NON-MATERIAL AMENDMENT NOTICE

Application No:	PL/2023/01587/NONMC
Case Officer:	Tristan Hazel
Date of Decision:	08.08.2023
Location:	Bosworth Wood Centre, Auckland Drive, Smiths Wood, Solihull
Proposed Development:	Non-material amendment to: 1- Change the trigger point of condition 9, 2 - Replace approved plan 001478-ADP-00-00-DR-L1900-LANDSCAPE GA-D3 T14, with 001478-ADP-EX-00-DR-L-1900-Landscape GA S4 C20, following planning approval PL/2022/00491/PPFL.
Date Registered:	18th July 2023
Applicant:	Tilbury Douglas Construction Ltd
Agent:	Q +A Planning

DRAWING TITLE:
LANDSCAPE GA

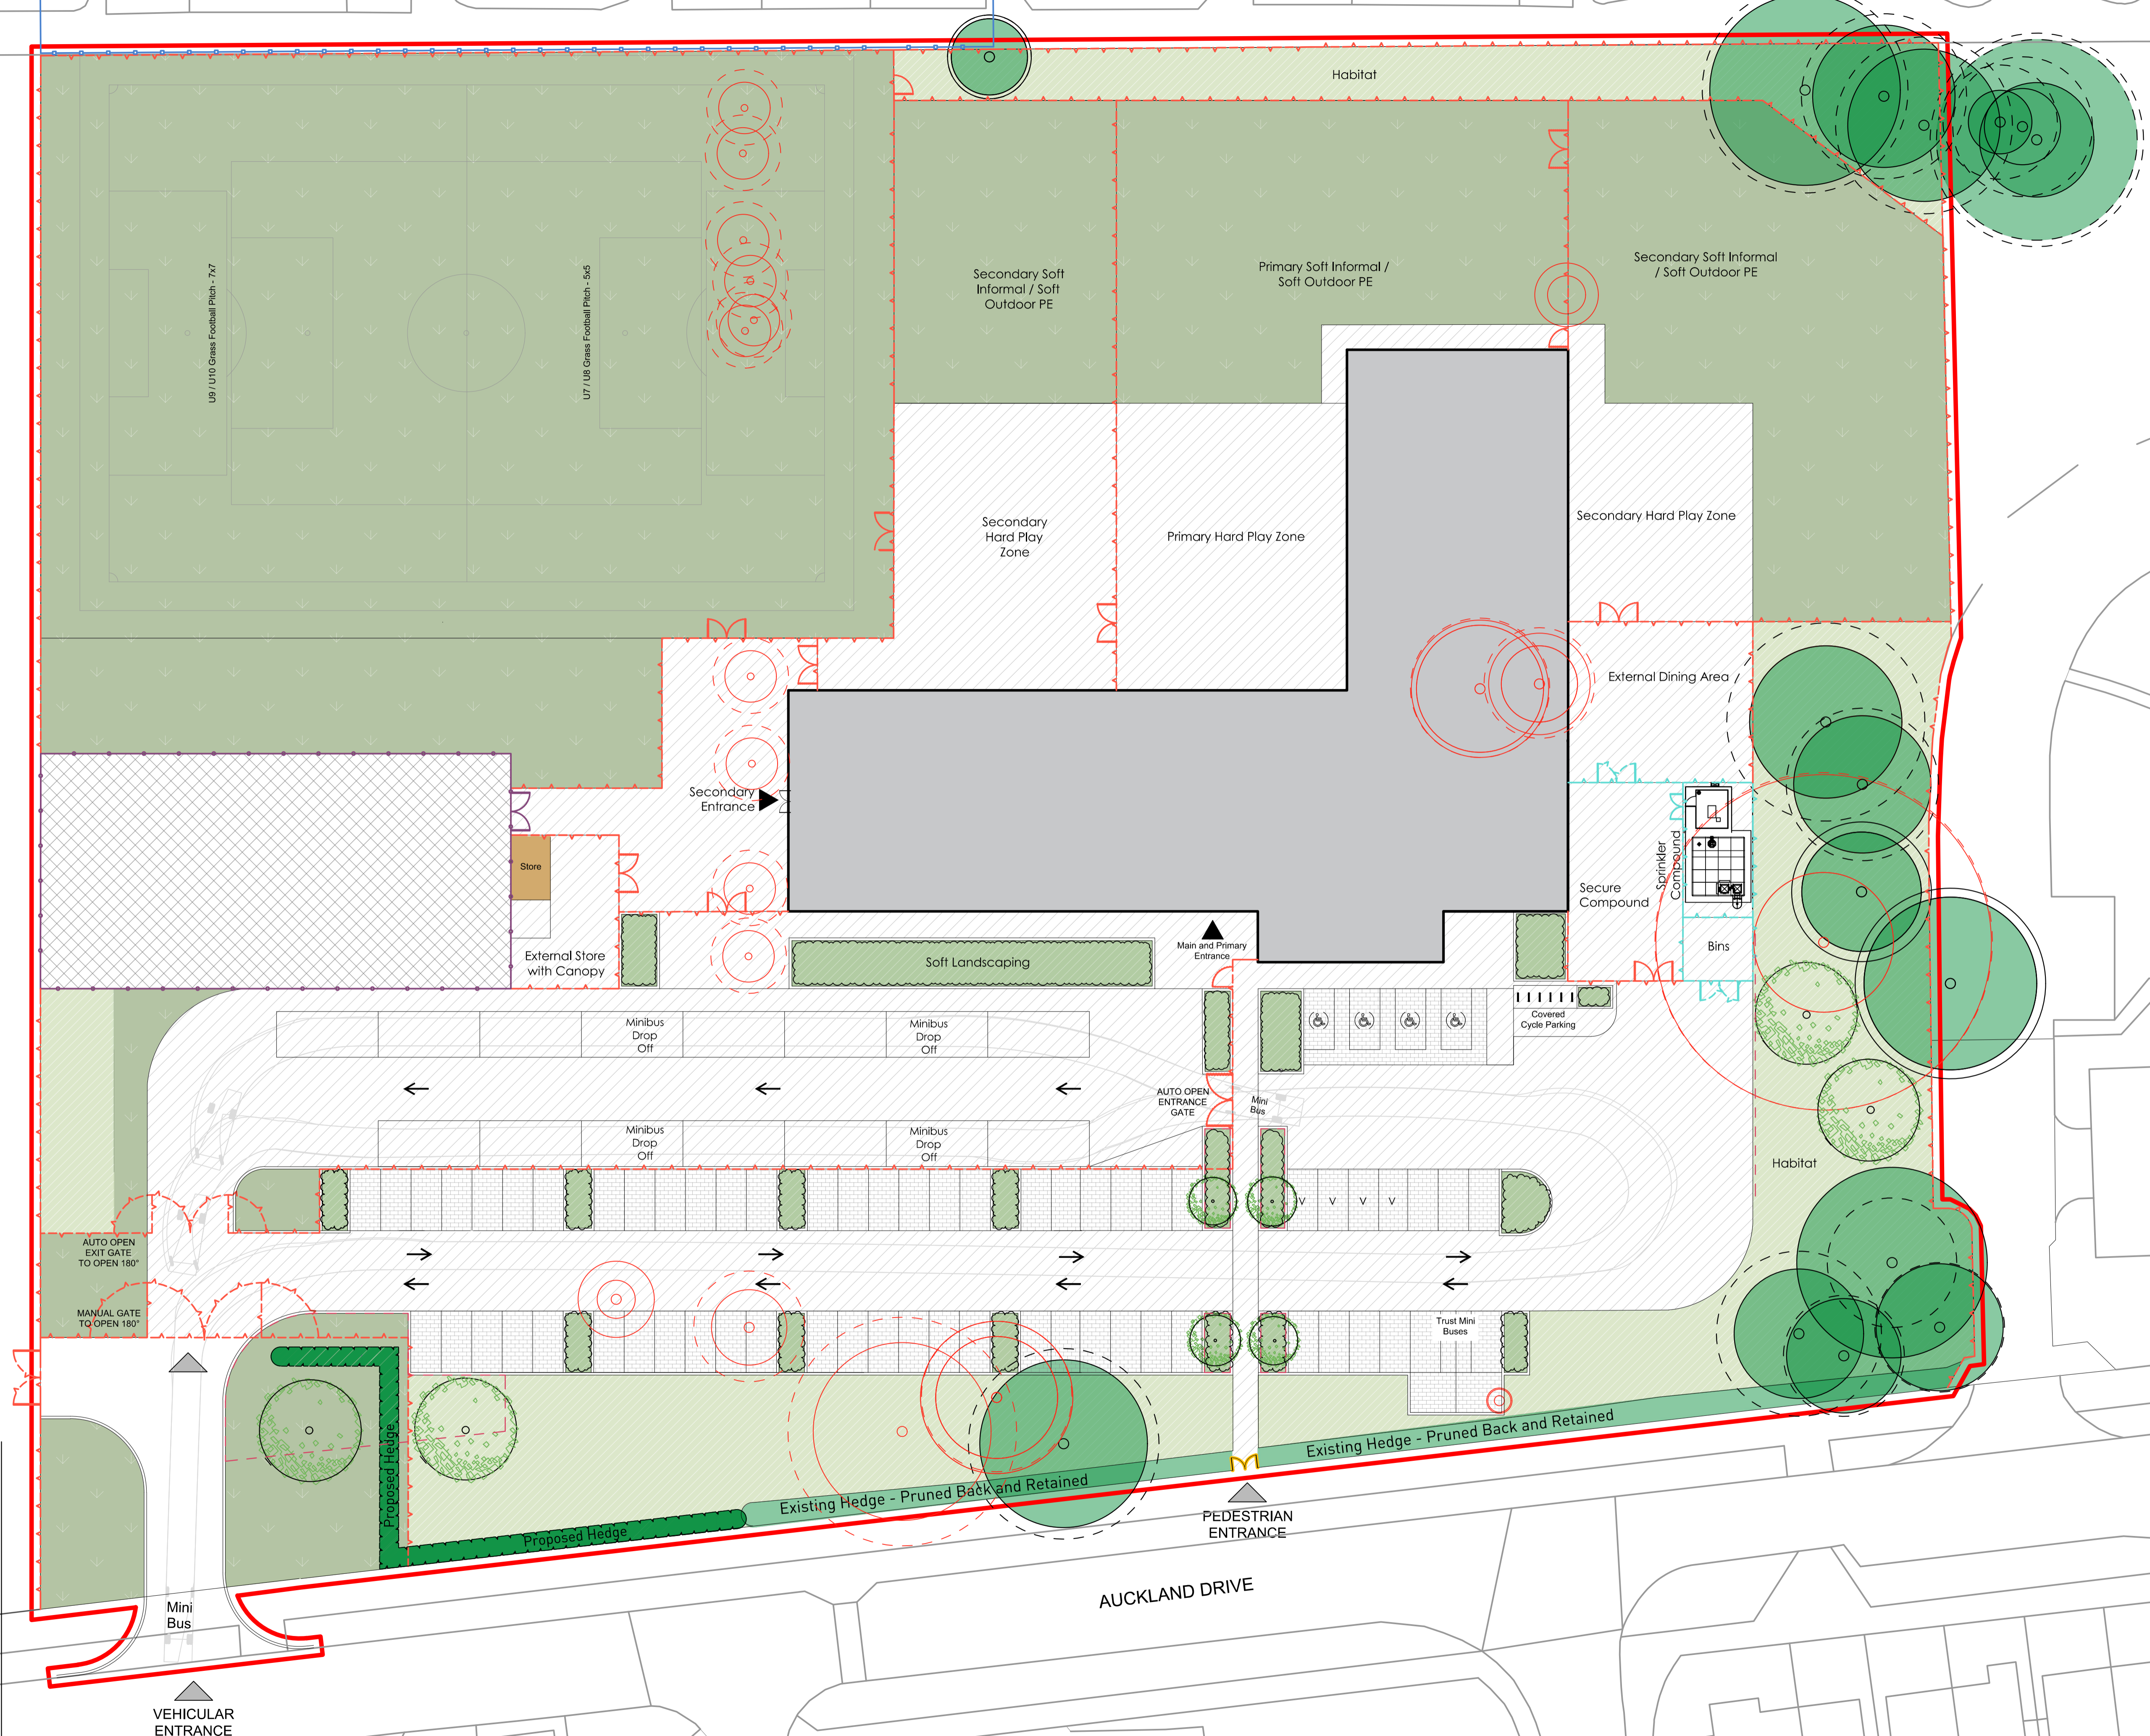
Landscaping plan: 001478-ADP-00-00-DR-L1900-LANDSCAPE GA-D3 T14, shall be replaced by, Landscaping plan: 001478-ADP-EX-00-DR-L-1900-Landscape GA S4 C20.
